CITY OF ALBUQUERQUE

June 11, 2015

**RE: 4th & Montano Dental Office
Grading and Drainage Plan
Engineers Stamp Date 5/14/15 (F14D055)**

RONALD R. BOHANNAN P.E. #7868	<b>4TH ST AND MONTANO DENTAL OFFICE</b>	DRAWN BY DY
	<b>GRADING AND DRAINAGE PLAN</b>	DATE 6/30/15
 <b>TIERRA WEST, LLC</b> 5571 MIDWAY PARK PLACE NE ALBUQUERQUE, NM 87109 (505) 858-3100 www.tierrowestllc.com		2014099-GRE
		SHEET # <b>C3</b>
		JOB # 2014099

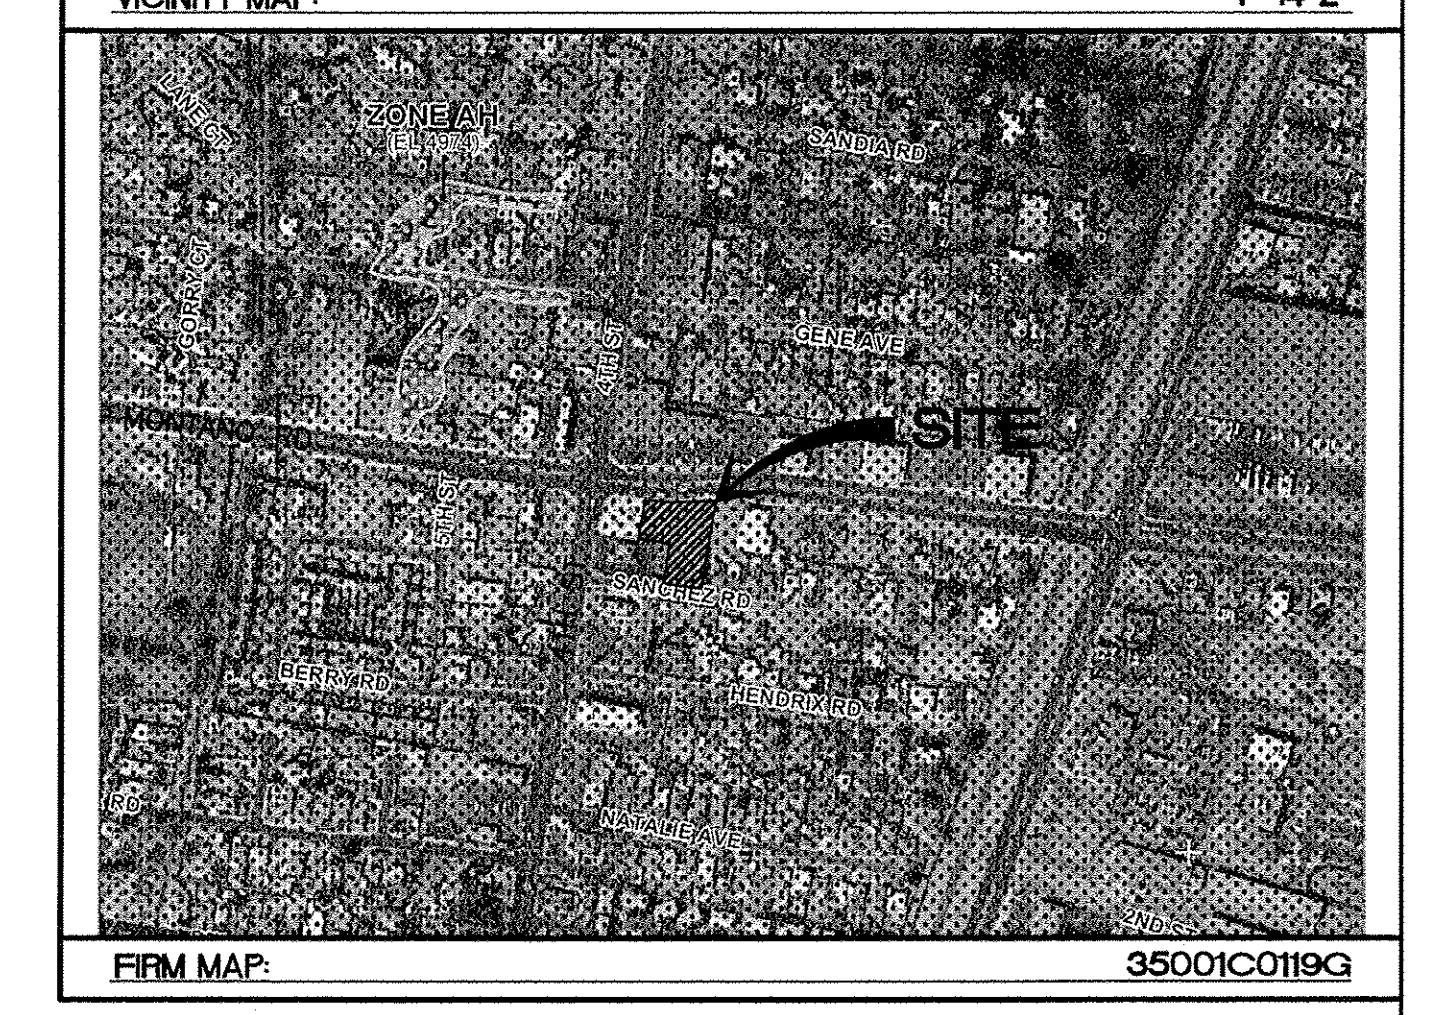
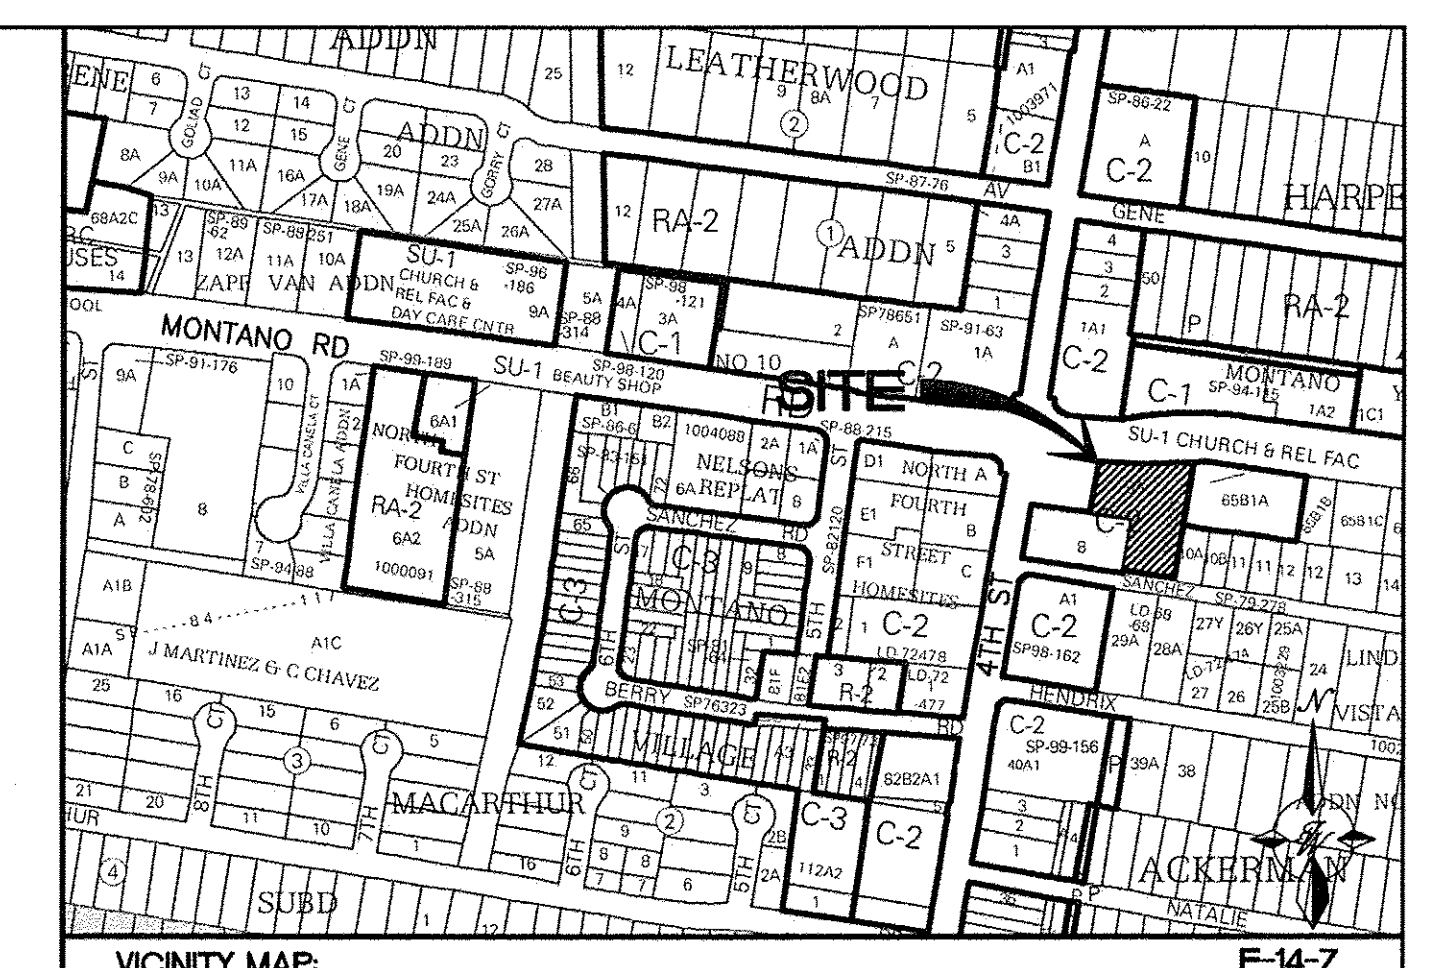
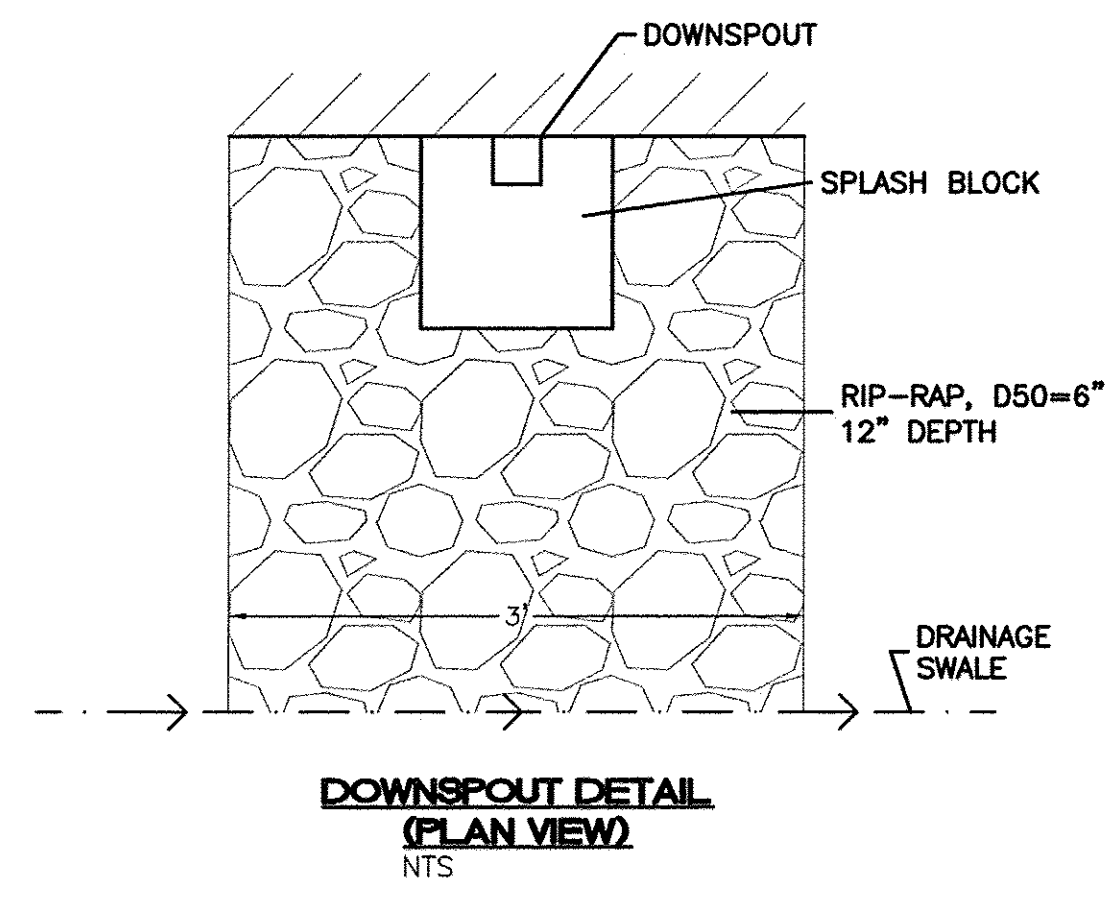
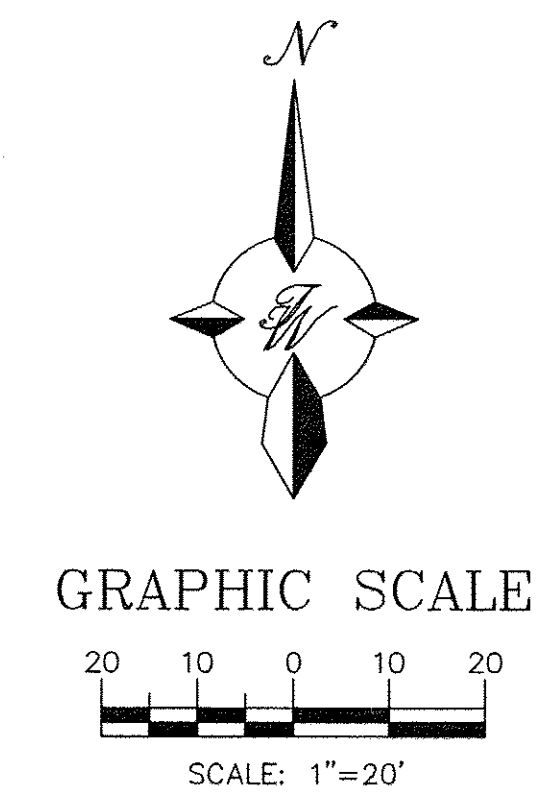
- Are the west and south areas of the building landscaped?
- A cross lot drainage agreement is needed from the owners to the south.
- Is curbing in place at the existing south parking area? If so, curb cuts will be needed.
- How are flows from the roof directed away from the building?
- What is the double line in the north landscaped area? Is this a sidewalk culvert?
